**EMBREY BUILDERS, LLC.**

**RFI**

RFI #: 121  
Date: 5/18/2012  
Job: EB-02 Keller Springs Lofts  
Phone: 877-777-5115

Subject: Floor Truss Support at A2-SP Unit

**A2-SP ONE BEDROOM/ONE BATH**  
SCALE 1/4"=1'-0"

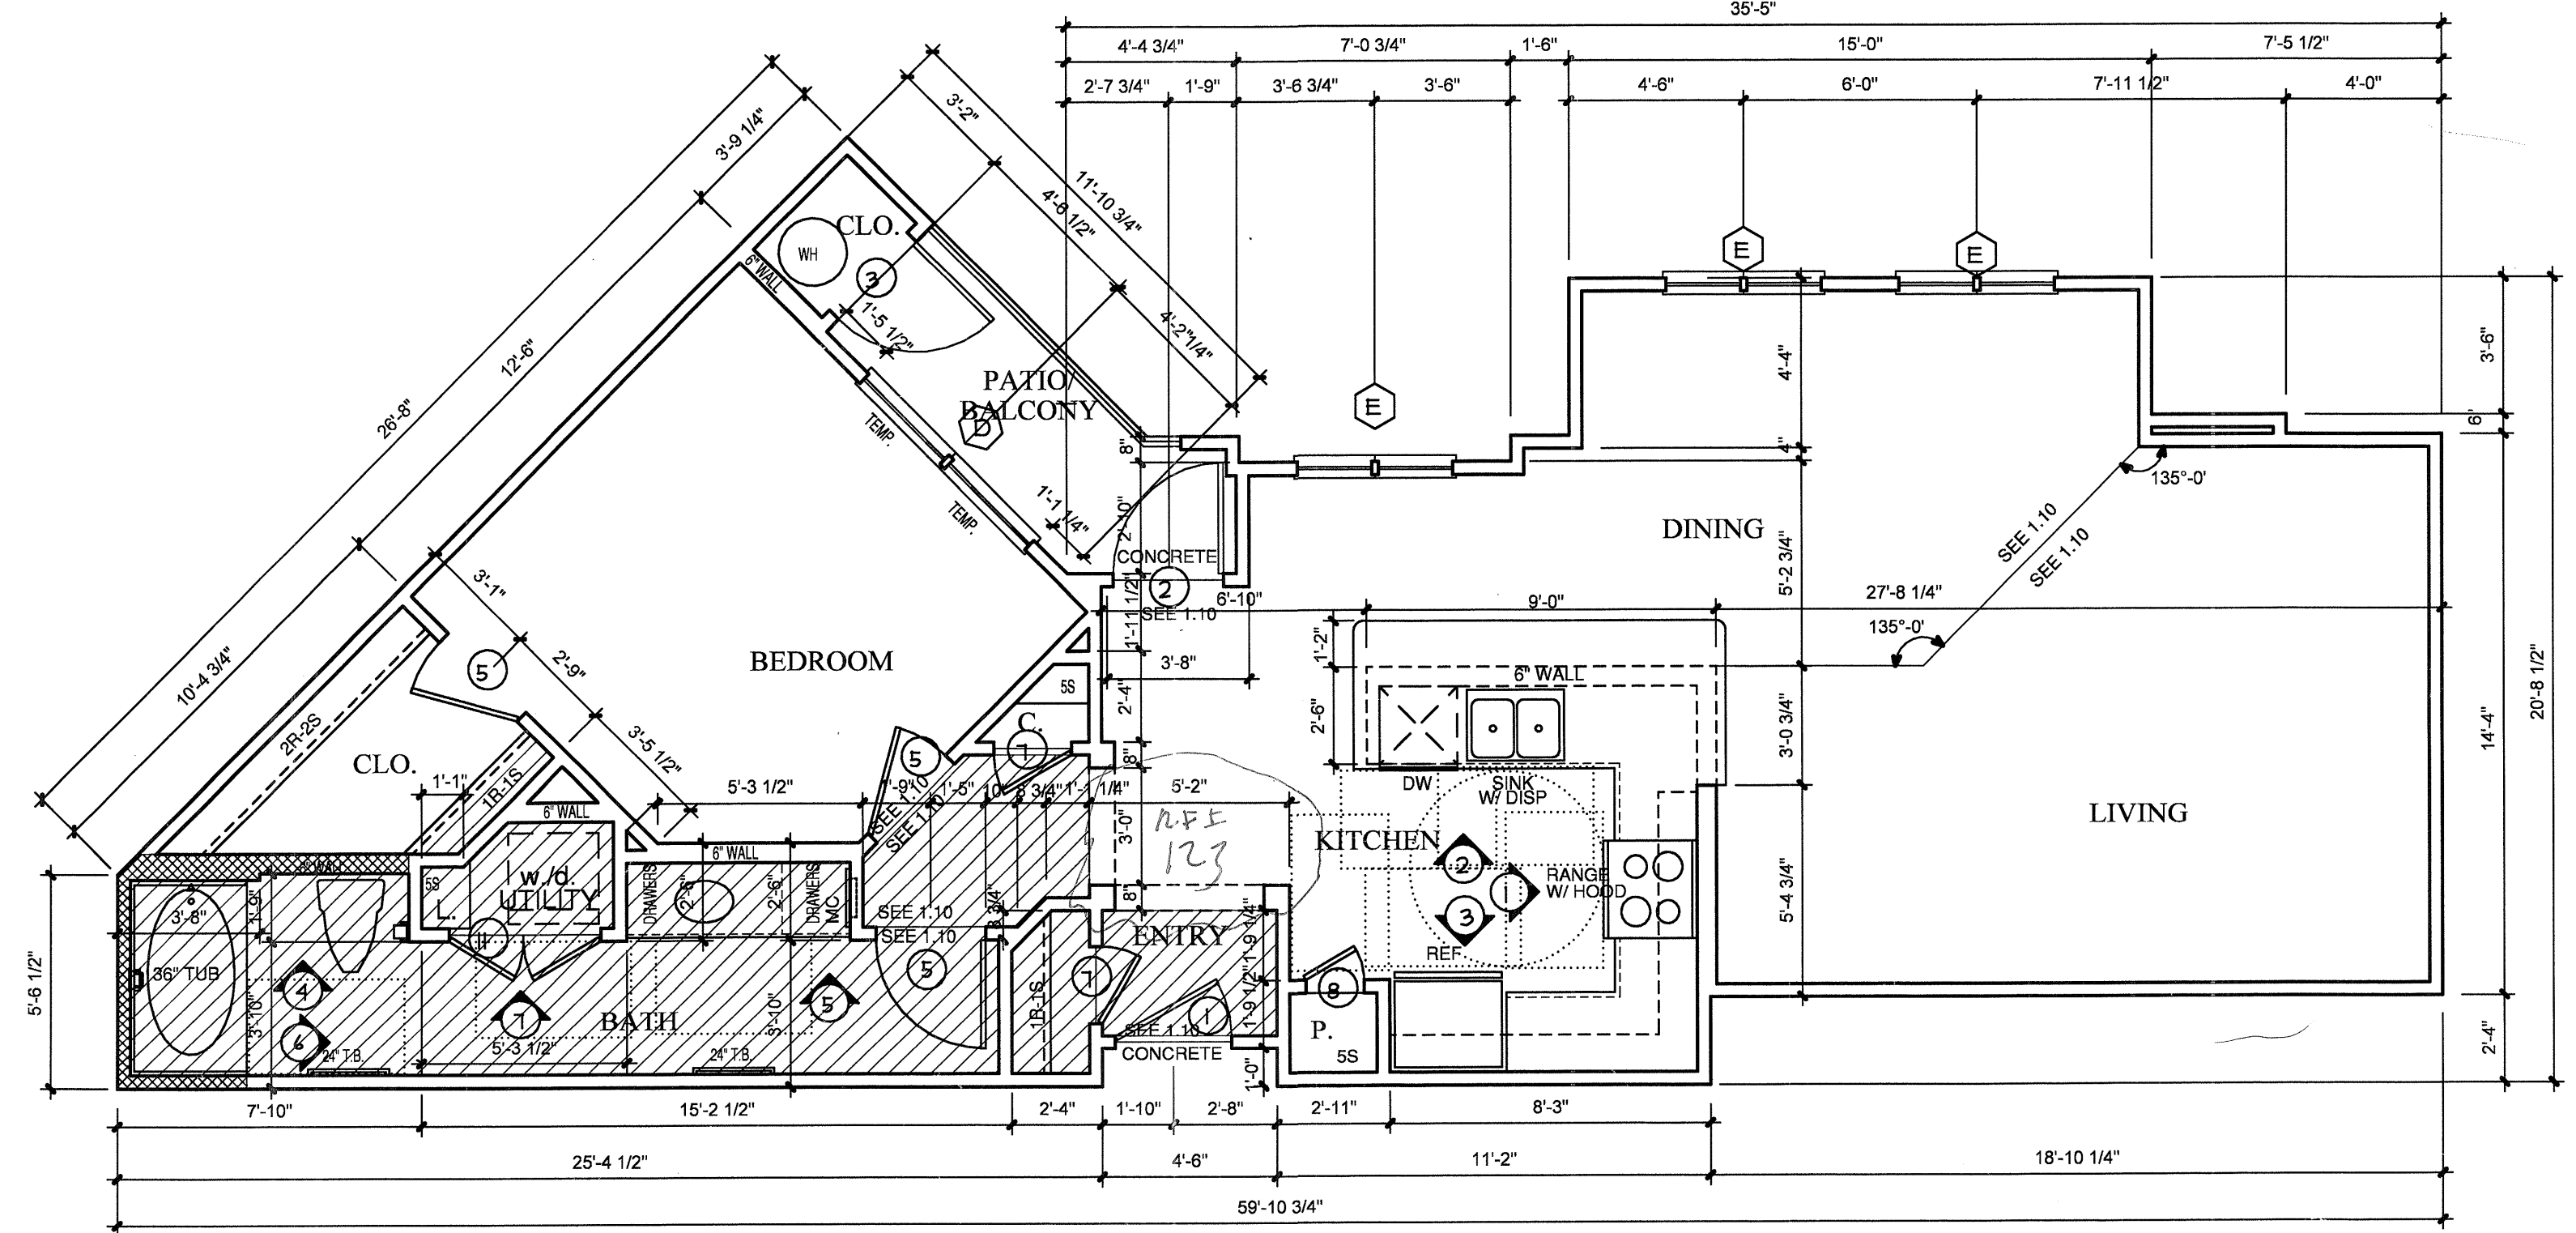
**Request:** Date Required: 5/25/2012  
The 2nd floor plan on S2.23 will work with the steel beams supporting the trusses above. The 3rd floor plan on S2.33 shows the trusses to span from the corridor wall to the exterior wall of the A2-SP unit. Please confirm that the steel support below will support the trusses bearing on the exterior wall for the units above.

As discussed on site, the W16x36 and W16x77 beams have been designed to "cantilever" through the W24x76 beam using a "moment connection" as shown in detail 4/S4.01.

An additional plate is required at the W10x12 per attached.
